**From:** Nicola Swann [REDACTED]  
**Sent:** 15 January 2025 13:37  
**To:** Planning.Responses  
**Subject:** Pagham responses

P/114/24/RES – Land west of Pagham Road Pagham. Approval of the reserved matters following approval of P/178/21/OUT for 95 new homes along with supporting infrastructure in the form of access, new pedestrian and cycle links, open space, landscaping, habitat creation, drainage features and associated groundworks and infrastructure. This application is a departure from the development plan, is in CIL zone 5 (CIL liable as new dwellings) and may affect the setting of listed buildings. RESOLVED: NO OBJECTION, however the Council wished to raise the following points:

Play & Recreation

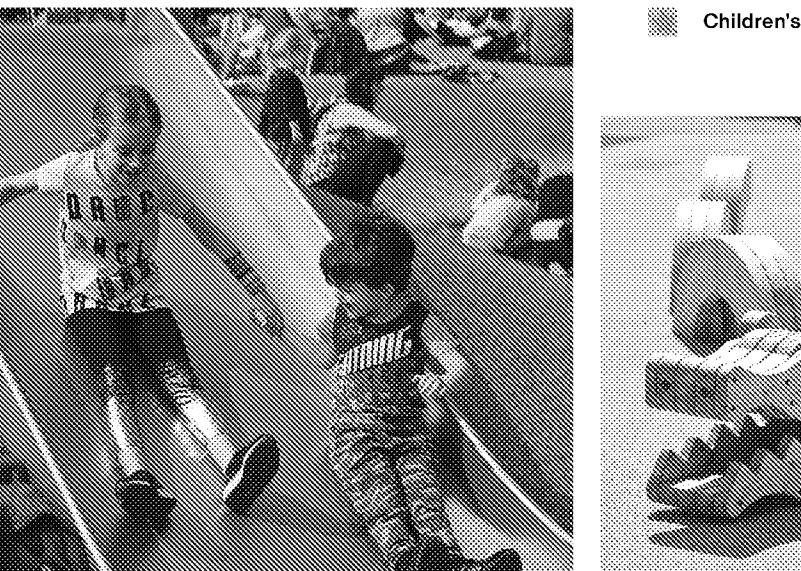
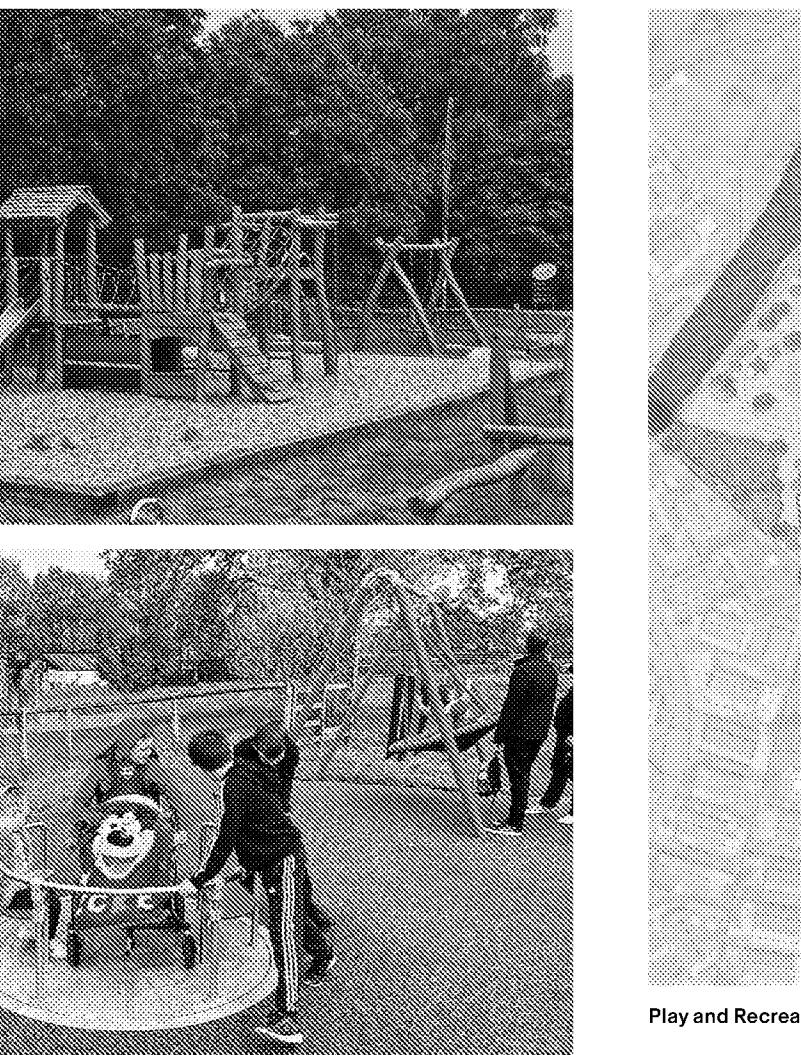
Members feel there are further measures the developer could take in respect of climate change. We have asked that grey water systems, porous driveways and solar panels are included on all properties. We would like confirmation that there will be fencing around the toddler play area which is next to the attenuation pond.
